From: Contact Centre (CRM) <contact@ribblevalley.gov.uk>
Sent: 20 February 2024 16:31
To: Planning
Subject: Planning Application Comments - 3/2023/0997 FS-Case-588535821

Planning Application Reference No.: 3/2023/0997

Address of Development: The Royal British Legion Towneley Road Longridge PR3 3EA

Ground Floor Plan

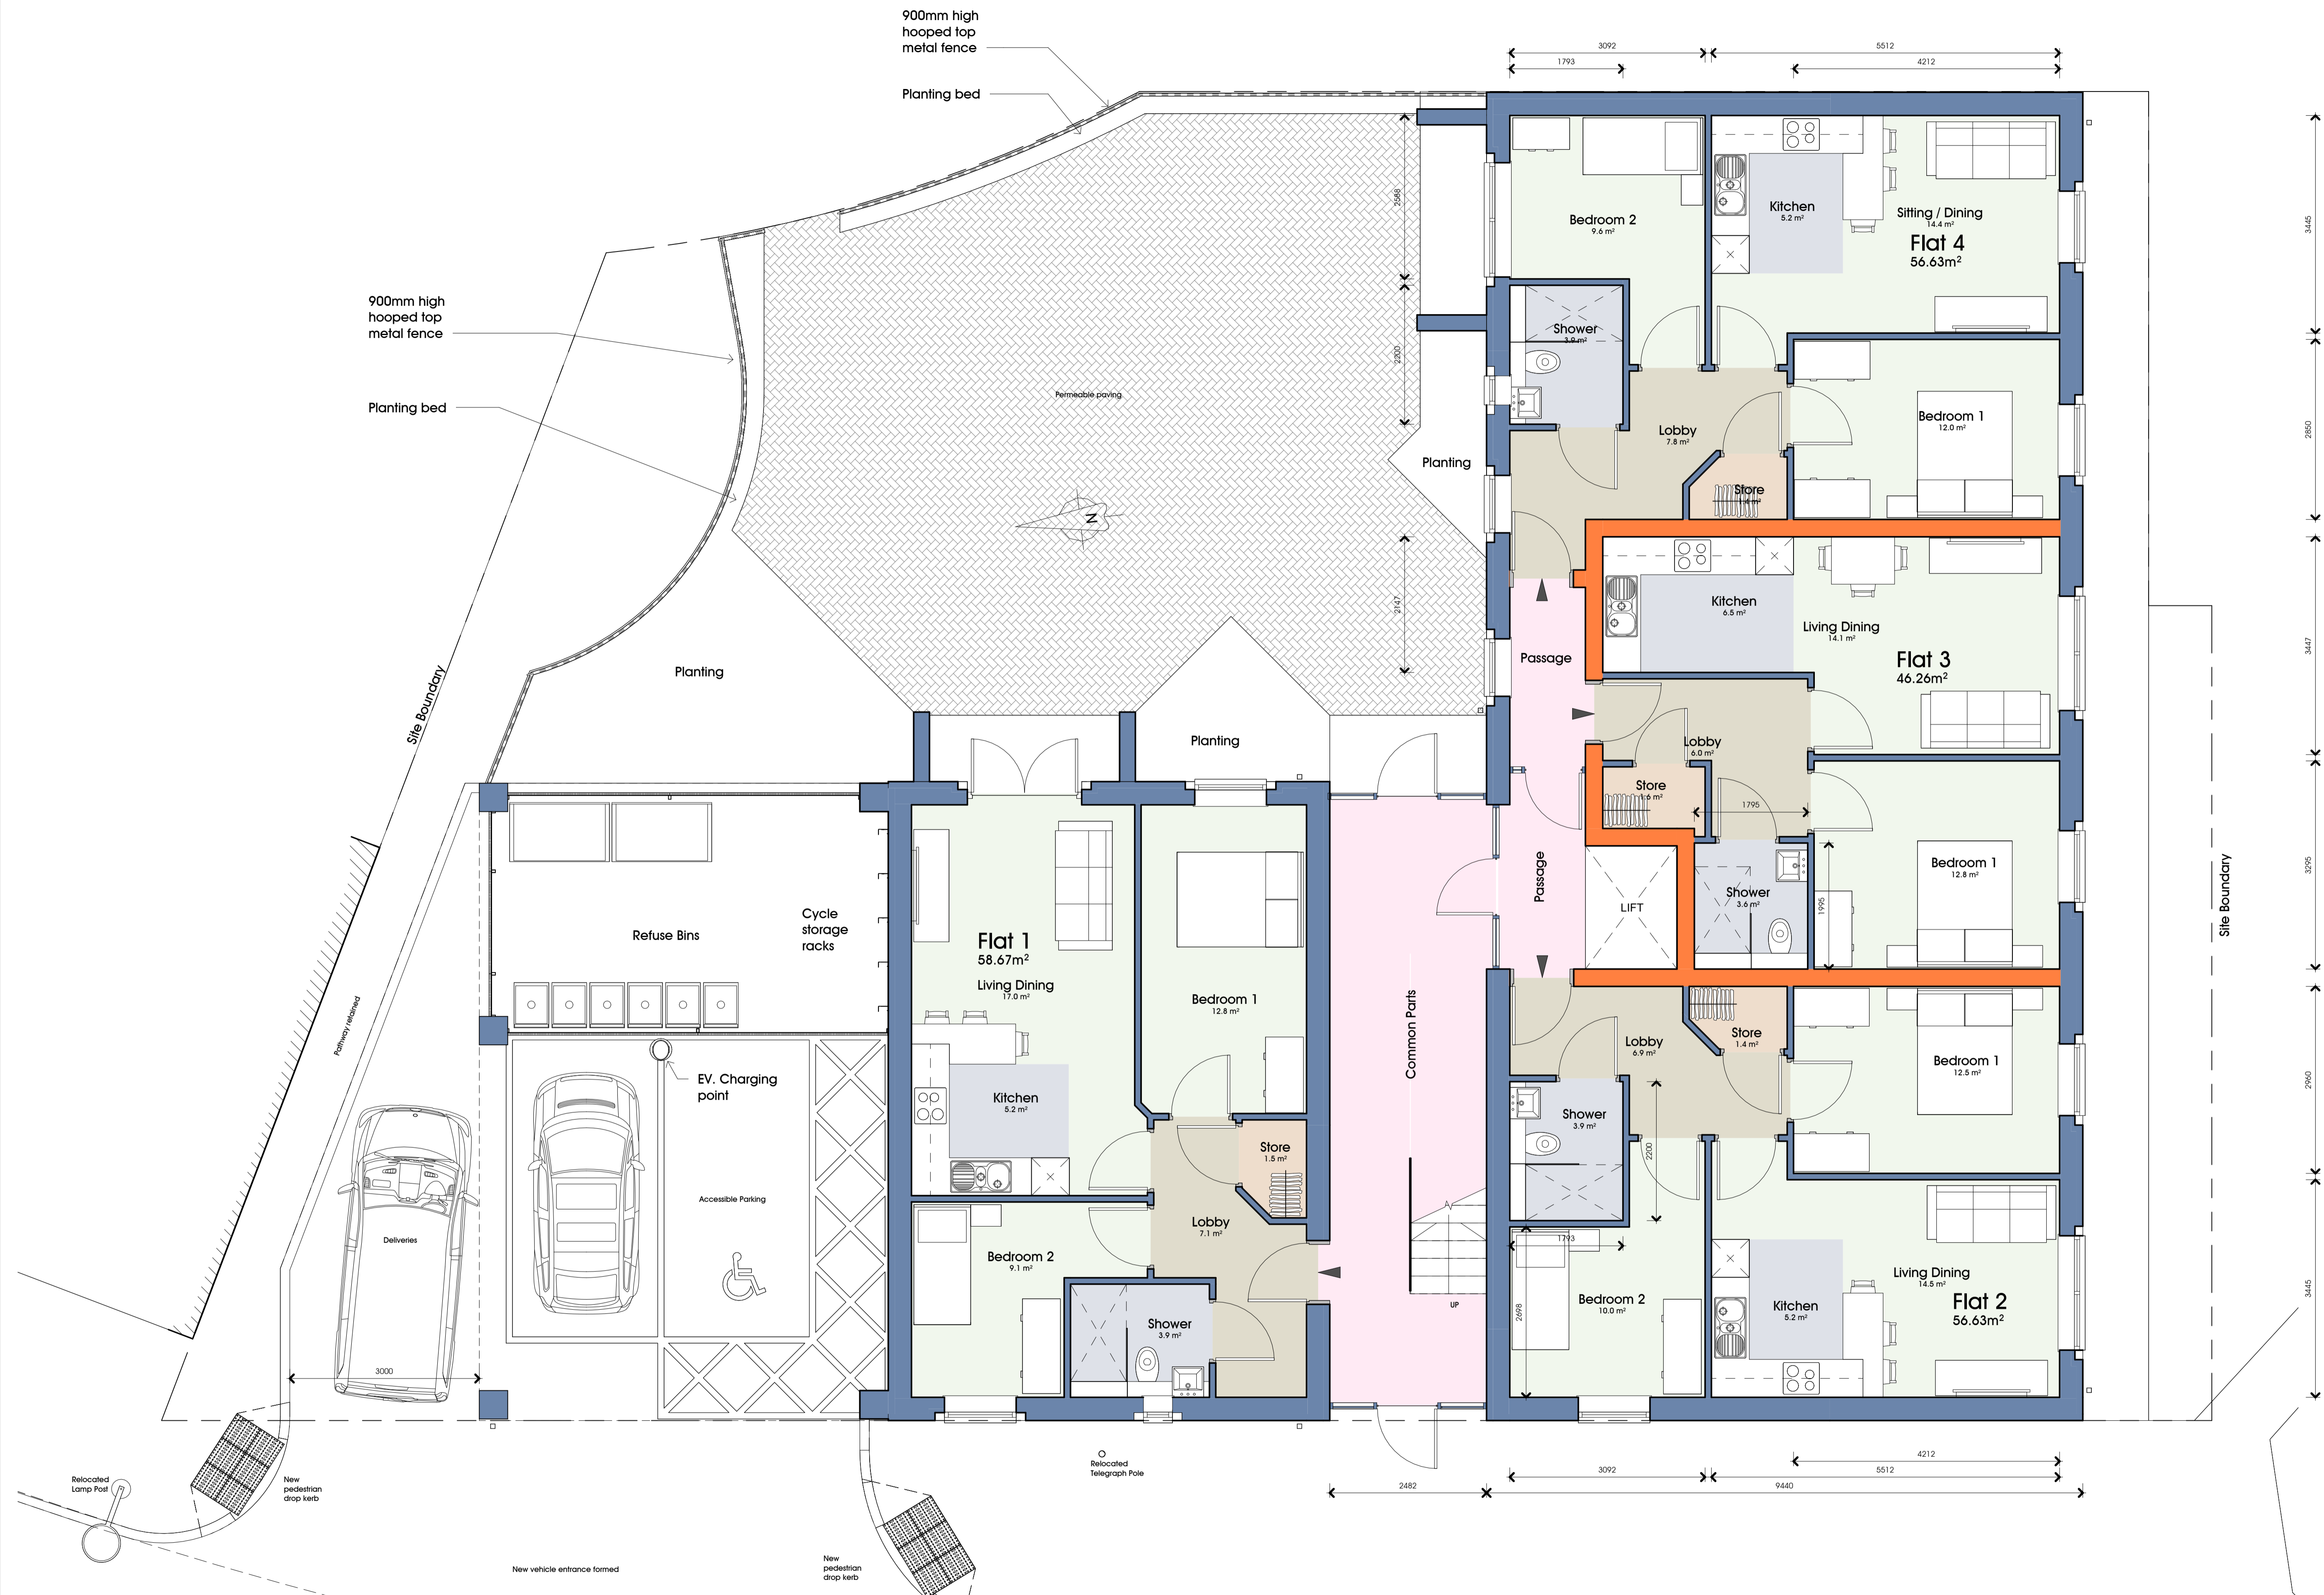
Comments: [REDACTED] and know what the traffic on Towneley road can be like I have an issue with this application of 12 apartments with no car parking spaces we have all the workers who work on berry lane parking on Towneley road during shop/business opening times I live [REDACTED] at [REDACTED] and I have cars parked outside my drive way blocking me in sometimes by workers and shoppers off berry lane. Cars park on both side of Towneley road making it hard to past other traffic to have another 12 apartments even if they don't all have cars you will have visitors visiting apartments so to have no car parking spaces is crazy .
